SSD_7054: LEES 1 BUILDING AND SSD_7055: F23 ADMINISTRATION BUILDING
UNIVERSITY OF SYDNEY RESPONSE TO SUBMISSIONS

The University of Sydney has reviewed all submissions received during the statutory public exhibition period of State Significant Application *SSD 7054 – F07 LEES 1 Building* and the *SSD 7055 – F23 Administrative Building*, both located on the southern edge of the University's Camperdown campus fronting City Road.

**Figure 2 Existing and Erroneous Layouts**

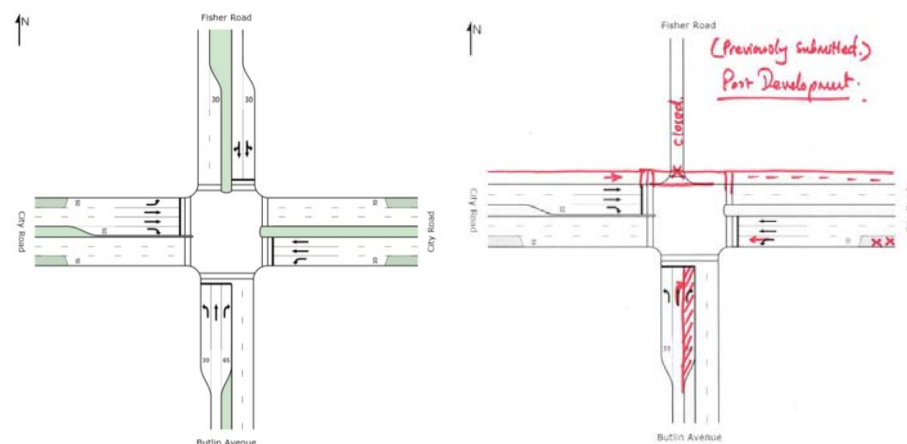
5. Clarification is required regarding the modelled decrease to the City Road/Butlin Avenue intersection level of service for pedestrian movements during a AM and PM periods, when the proposal seeks to significantly increase the importance of pedestrians and improve pedestrian amenity.

A detailed review of the previously submitted City Road/Butlin Avenue model revealed a geometrical error which resulted in the counter-intuitive output. Details are explained below.

The existing layout and previously submitted but erroneous layouts are shown on Figure 2 below.

Based on the above, the Sidra model has been revised to using the following parameters:

- A three-legged intersection (i.e. T-Intersection)
- Deletion of a northbound right turn bay
- Appointment of practical cycle time because the intersection is now modified, and therefore readapted signal timings.

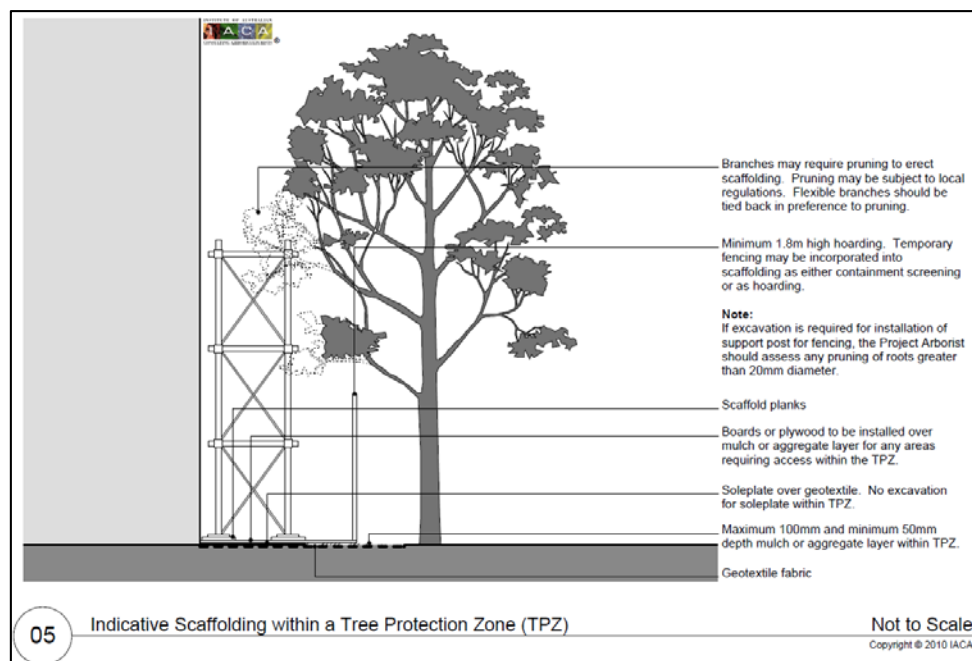
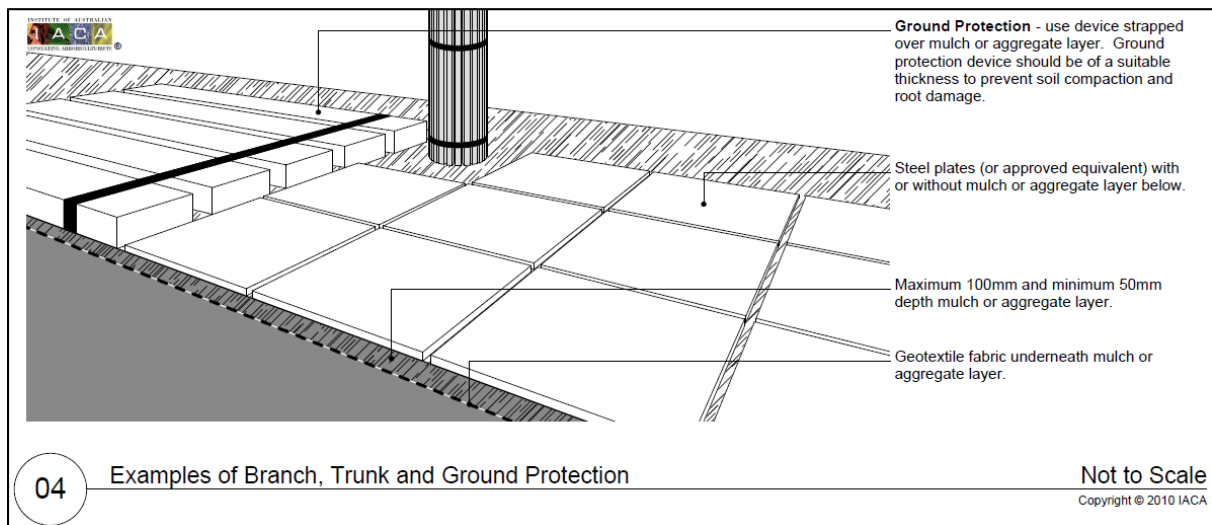
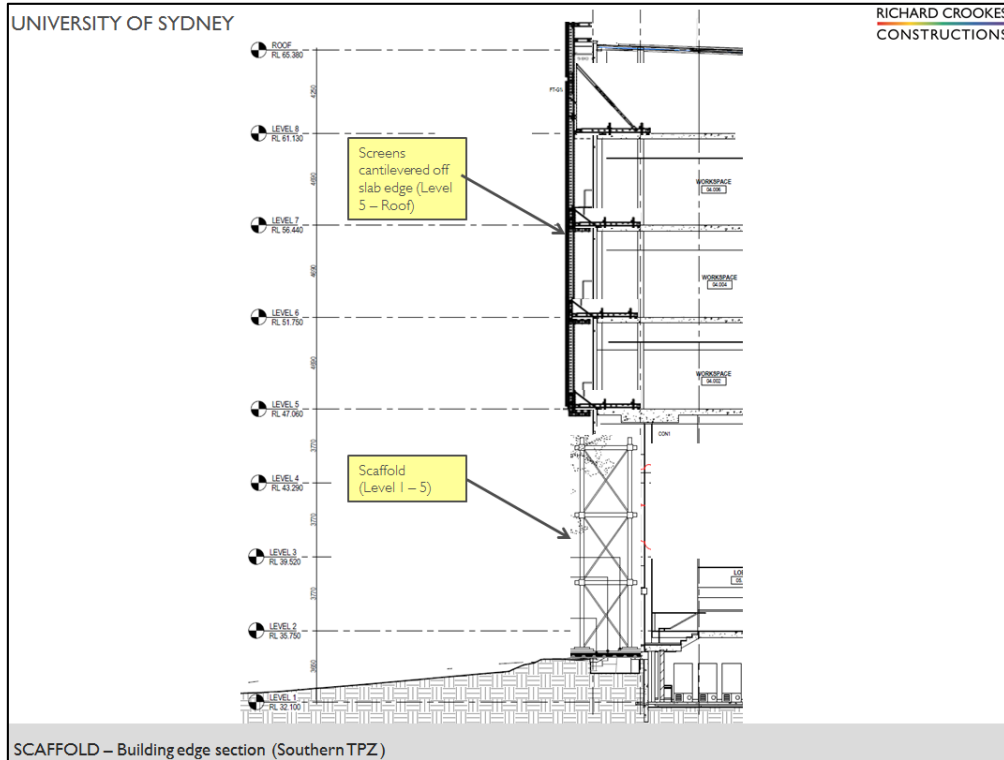
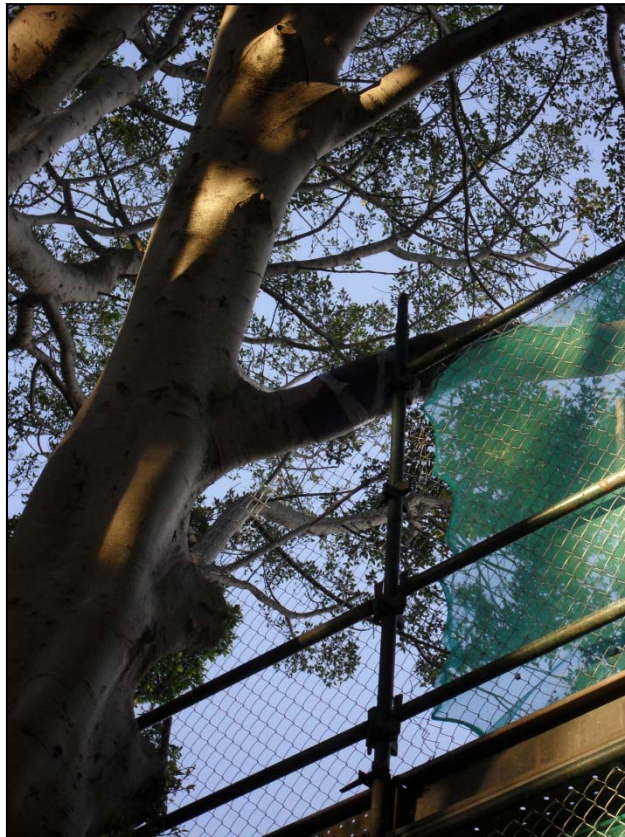
2. Landscaping and Trees The amount of pruning [<i>of the Moreton Bay Figs on City Road</i>] anticipated in the report does not reflect the distance of the proposed building or allow for scaffolding/hoarding, building clearance and potential construction access associated with construction. Further, the report does not consider any future allowance for tree canopy growth which will inevitably occur each year.	The proposed LEES1 Building has been designed to minimise impacts to, and to preserve and maintain, the City Road Figs. As part of the design development stage, arborist specialist consultants <i>TreeIQ</i> determined the maximum amount of pruning acceptable based on an individual assessment of the trees' crown form and the constraints of Australian Standard 4373 Pruning of Amenity Trees (2007). The proposed building was sited based on the trees' crown form, following these pruning works.
